From: Judith Ward
Sent: 25 October 2021 09:10
To: Rebekah Morgan
Subject: RE: Application 21/02177/DISC: Pioneer roundabout, Graven Hill

The attached amended plans have been in response to your comments. Please can you let me know if the overcome the previous concerns and if the condition can be discharged.

Amendments  
**GRAVENHILL, BICESTER**  
**A41 ROUNDABOUT LANDSCAPE GA SHEET 1 OF 3**

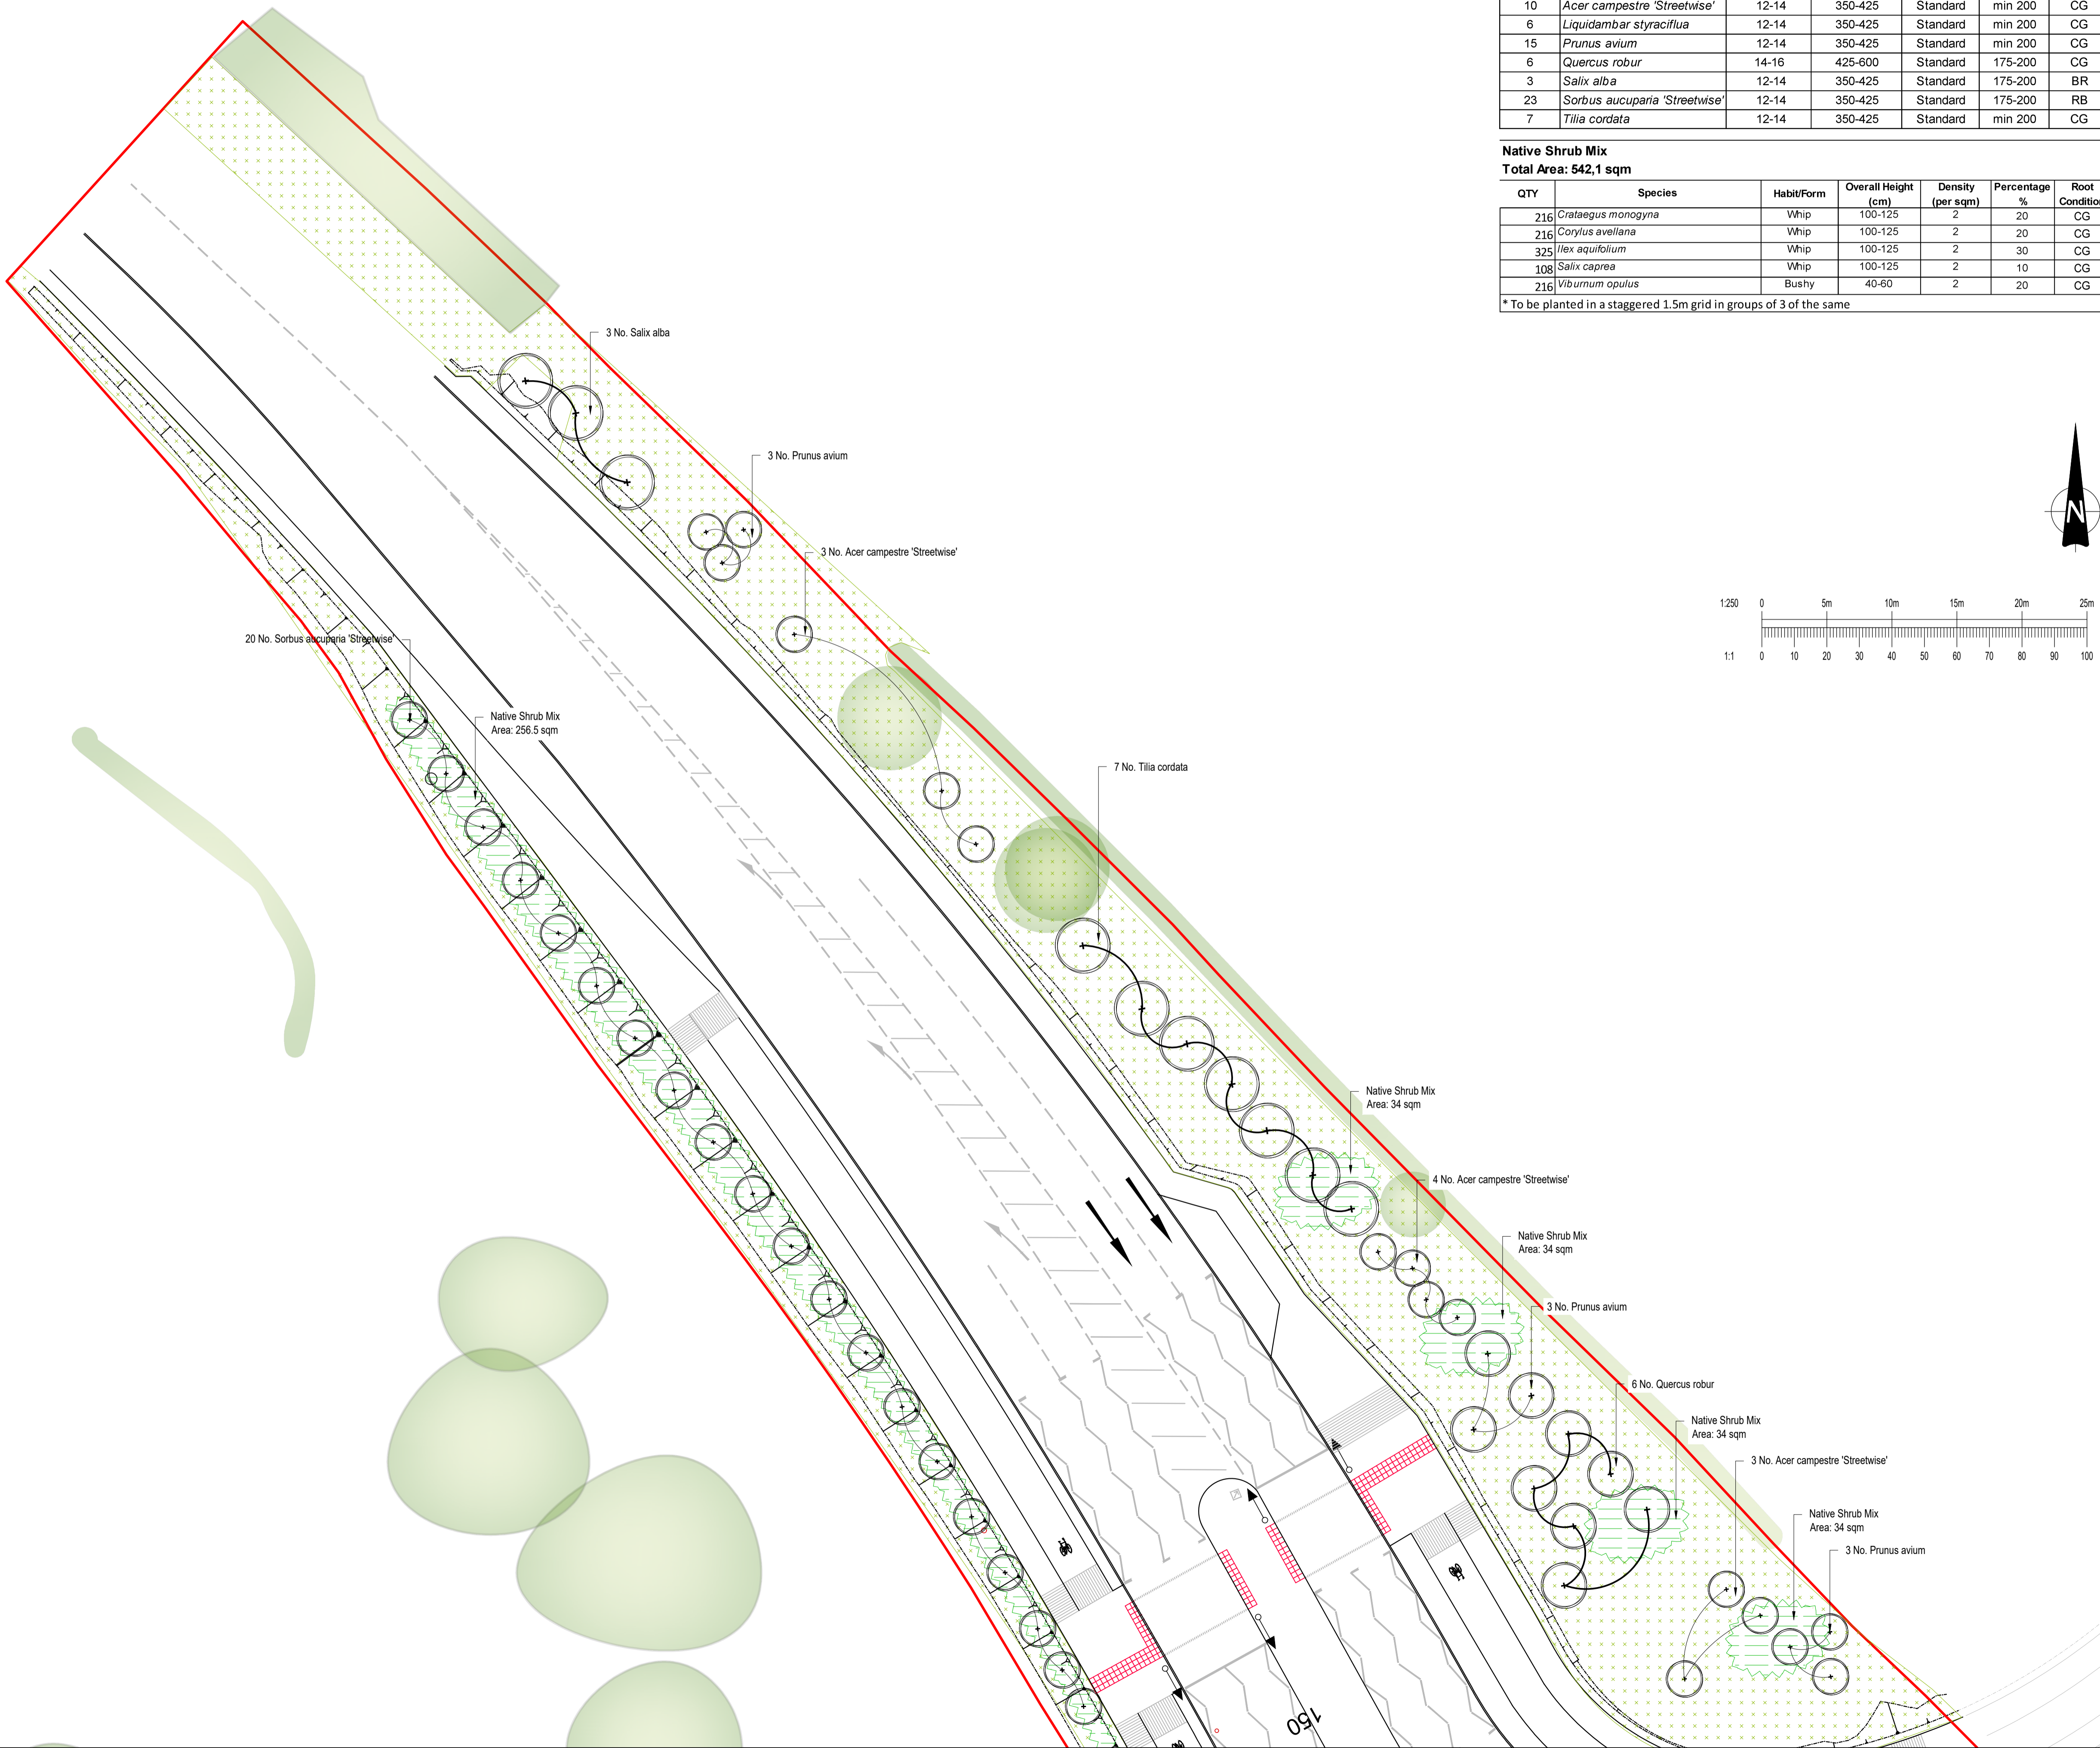
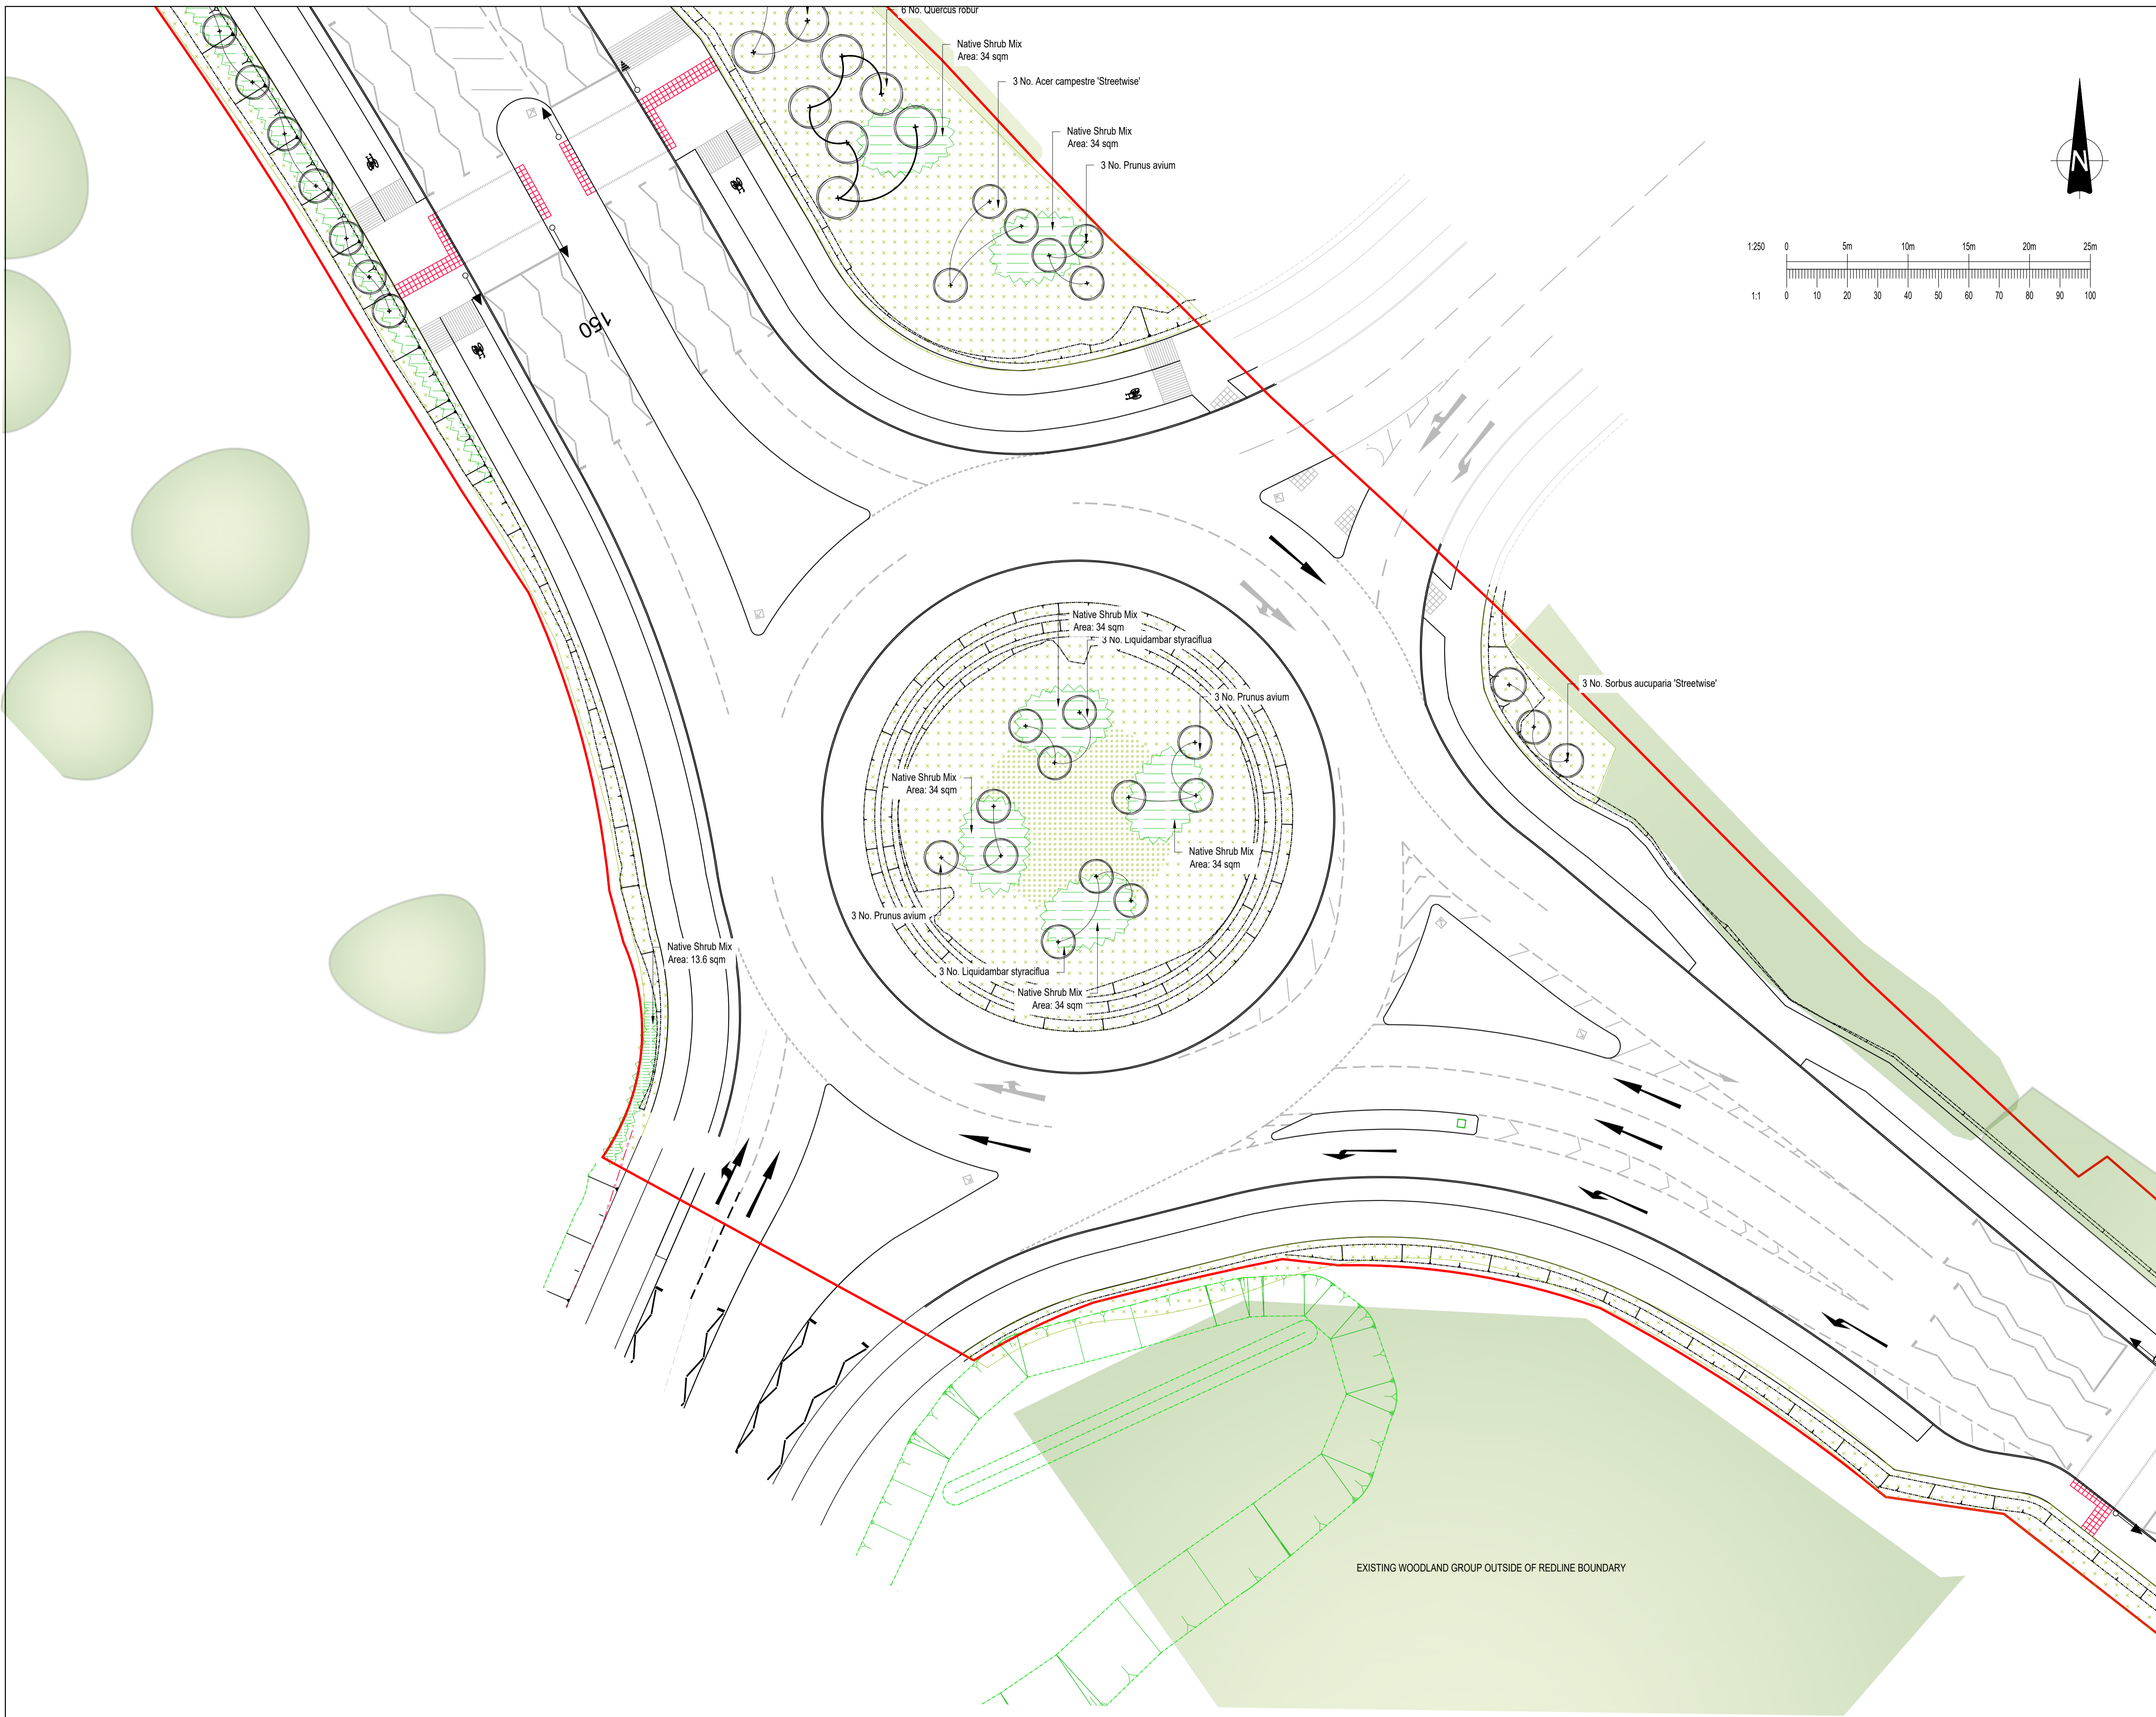
I can't see that any changes have been made.

Trees are still 14-16 I asked for larger trees at the entrance point to the site

Prunus still on plan. Prunus don't like heavy clay which we have here. They won't thrive.

Cornfield annuals still specified. Replace with perennial wild flower seed.
